### **P/53/19/L**

Listed building consent for the demolition of modern side extension & 2.25m of boundary wall.

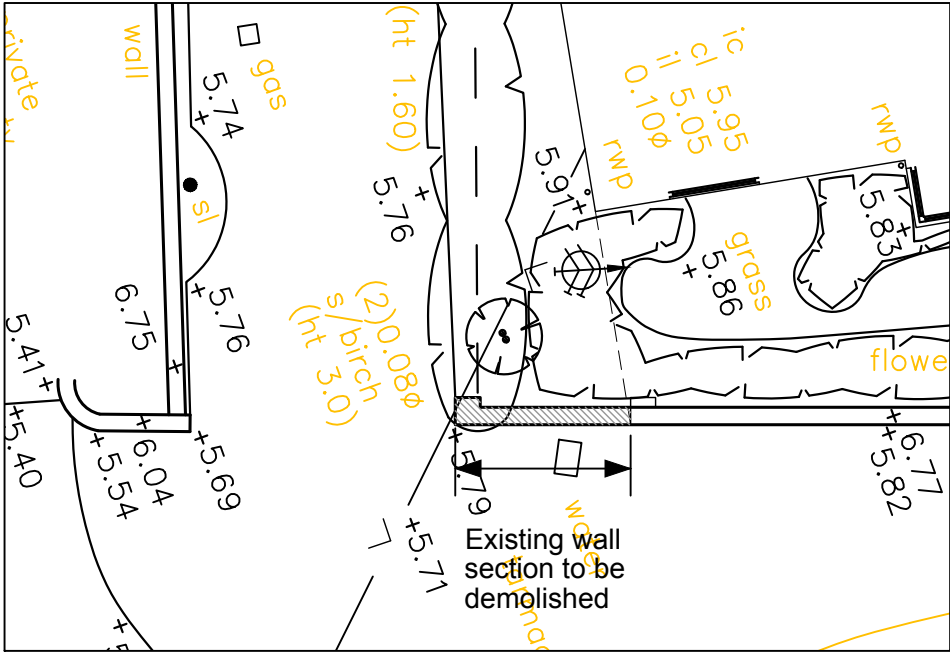
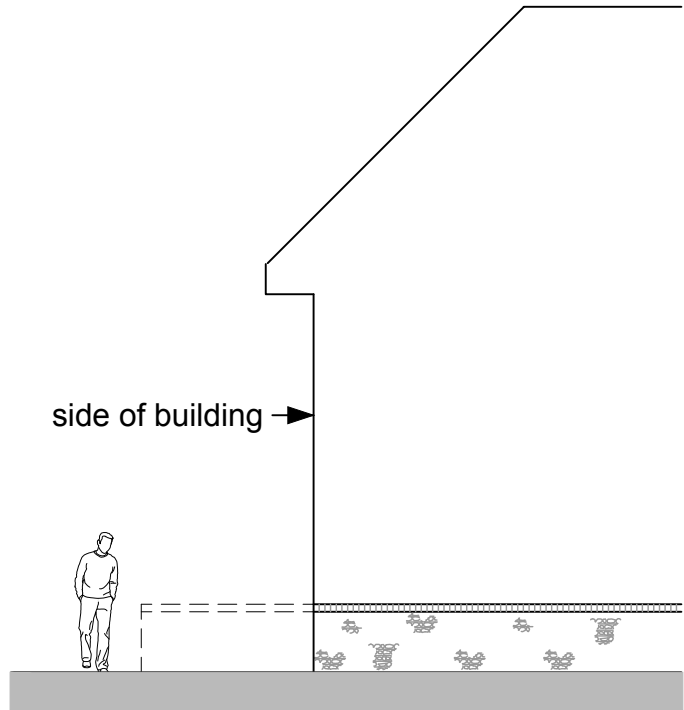
The section of the wall which is covered by this application consists of coursed 'rubble' stones. On inspection, it might be that the building material is that of 'Bognor Rock', which is traditional to the local area, and worthy of retention.

It appears as if the wall has been altered over time with the coping material varying along the length of the wall. I also note that the Heritage statement implies that the section of walling to be demolished has been rebuilt in recent times.

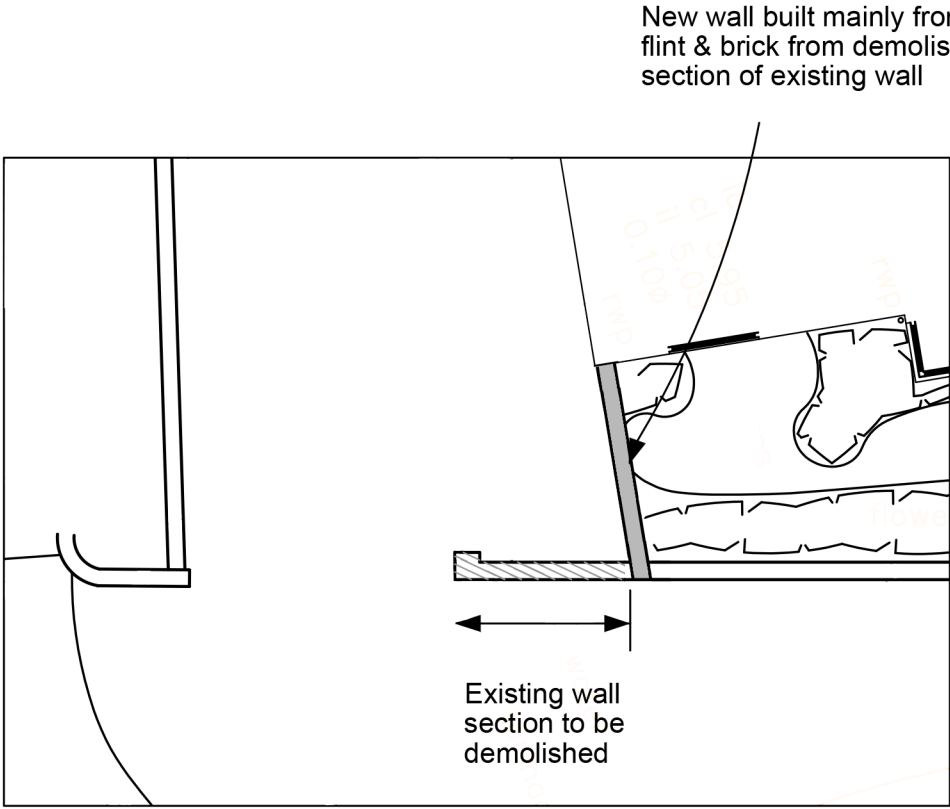
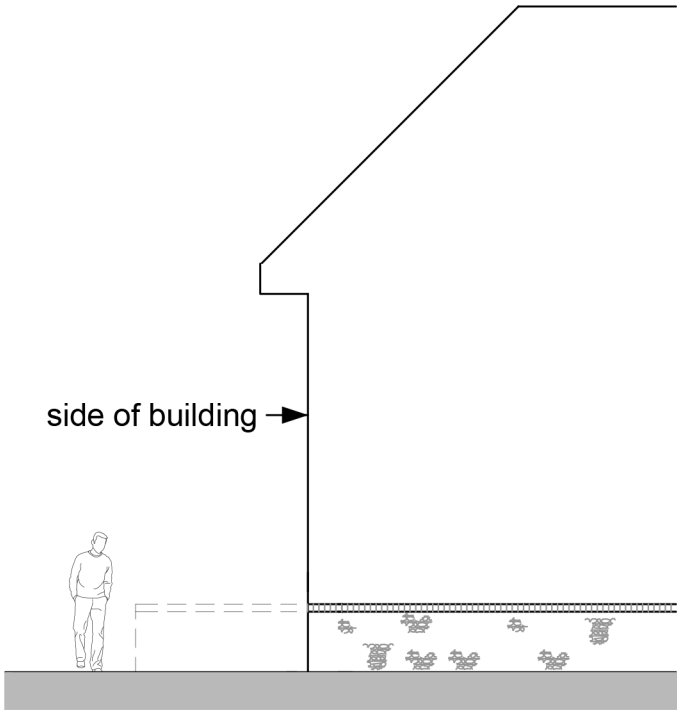
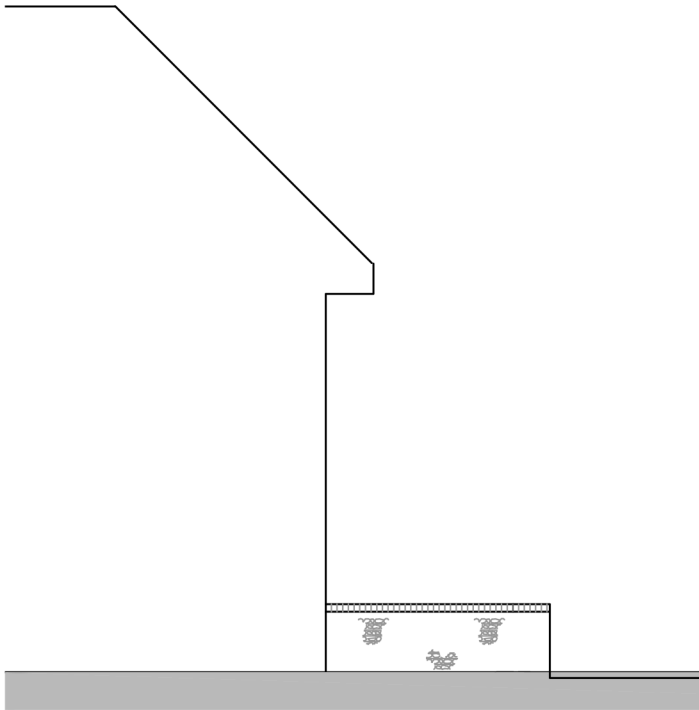
The revised proposal is to use the material removed from the demolished section of walling to create a new element which will link the remaining section of walling to the public house. The concept of re-using the existing material on site, whilst also ensuring that the wall is incorporated into the public house is an acceptable approach.

All of the existing materials should be carefully removed from the wall and stored prior to their re-use. Details of any new materials should be provided by the applicant in order to ensure that they reflect the existing ones. Further, you may wish to condition a sample panel or similar in order to ensure that the quality of the new section reflects that of the existing.
